Application No: H12-0463-23 **Applicant:** Mr Eagling

Proposal: Proposed Dwelling

Location: Land Adj 66 Gedney Road Long Sutton Spalding

CASE OFFICER ASSESSMENT

SITE PLAN 1:200

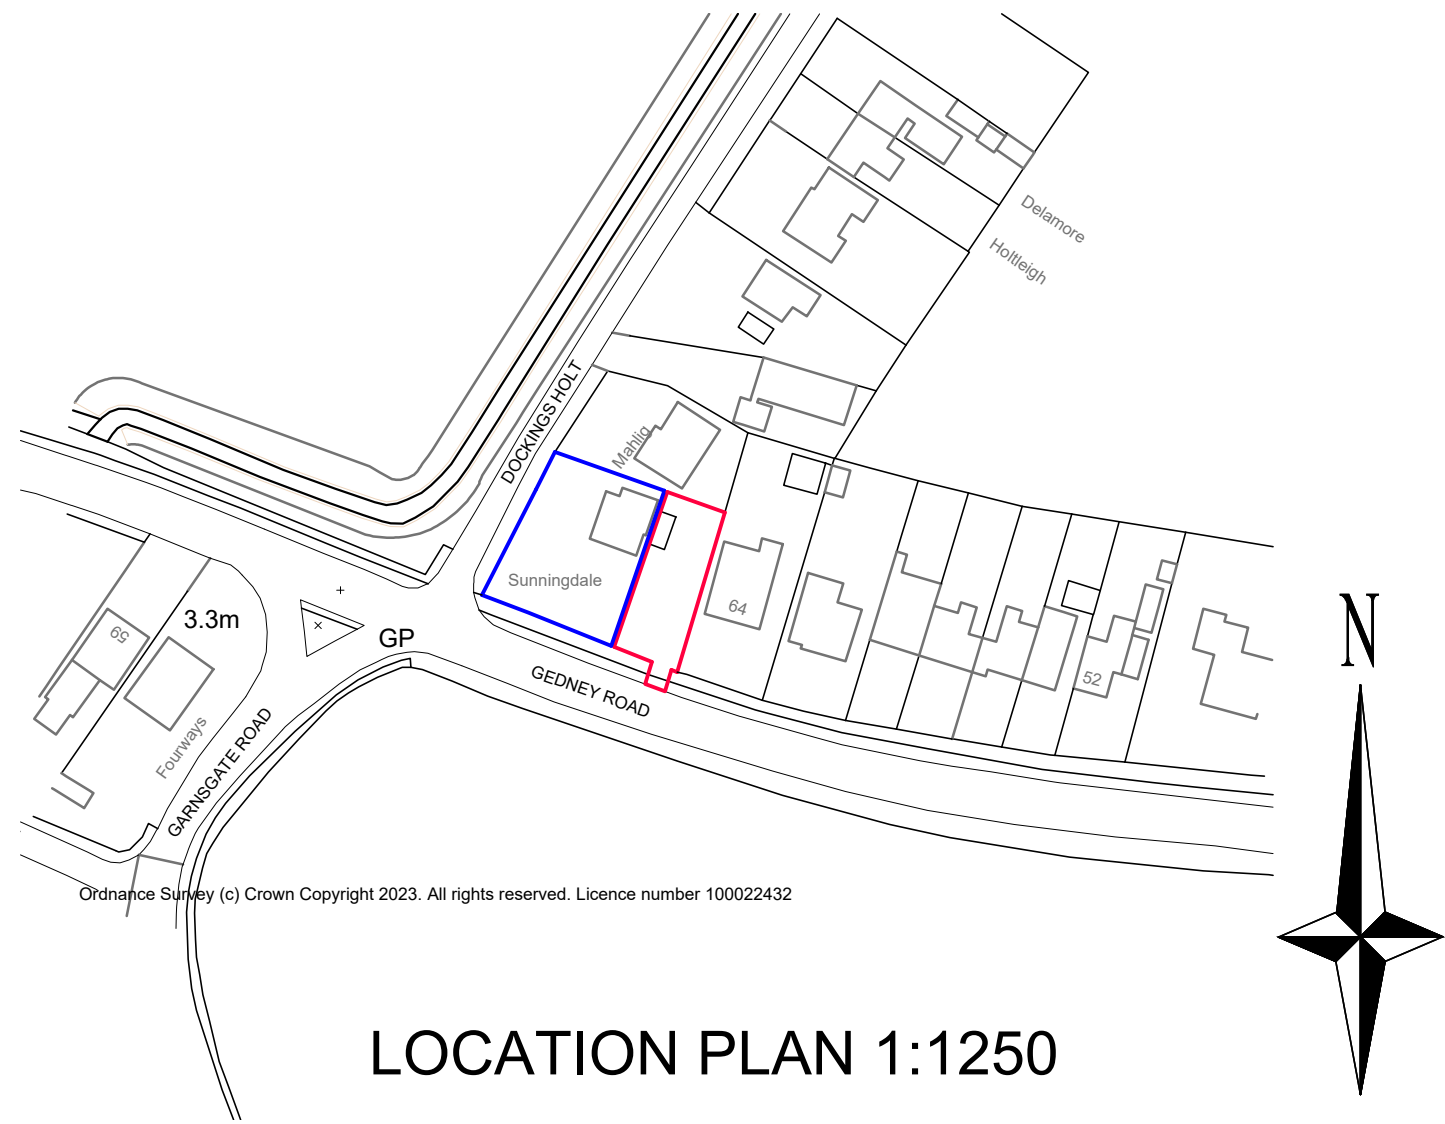
The applicant has indicated that they intend to dispose of surface water via infiltration, however I cannot see that the viability of this proposal has been evidenced. We recommend that ground investigation is carried out to determine infiltration potential, followed by testing in line with BRE Digest 365 if onsite material is considered favourable for infiltration. If infiltration is not feasible at this site, following the drainage hierarchy we would expect the applicant to propose to discharge surface water to a watercourse. In this case, consent would be required under Byelaw 3. Please note that we recommend that any discharge is in line with the Non-Statutory technical standards for sustainable drainage systems (SuDS), therefore the Board is unlikely to grant consent for discharges in excess of greenfield rate.

Section 1 is fouled by this proposal on the grounds of the preservation of residential amenity. the adjacent 64 Gedney Road features 2, which is a bungalow, features 3 ground floor windows on its western elevation, 2 of which would be directly impacted by the eastern wall of the proposed dwelling. The effected elevation would be situated roughly 2m away from the proposed development with a entirely blank wall, with a ground floor window which would look directly into the centre window on the extant 64. The resultant inevitable loss of light, outlook and privacy for 64 would represent an unacceptably harmful impact upon that property's residential amenity. Additionally, by the same consideration, section 6 of the above Policy 2 is in conflict, by representing a visual intrusion to the outlook of domestic space within 64 Gedney Road.
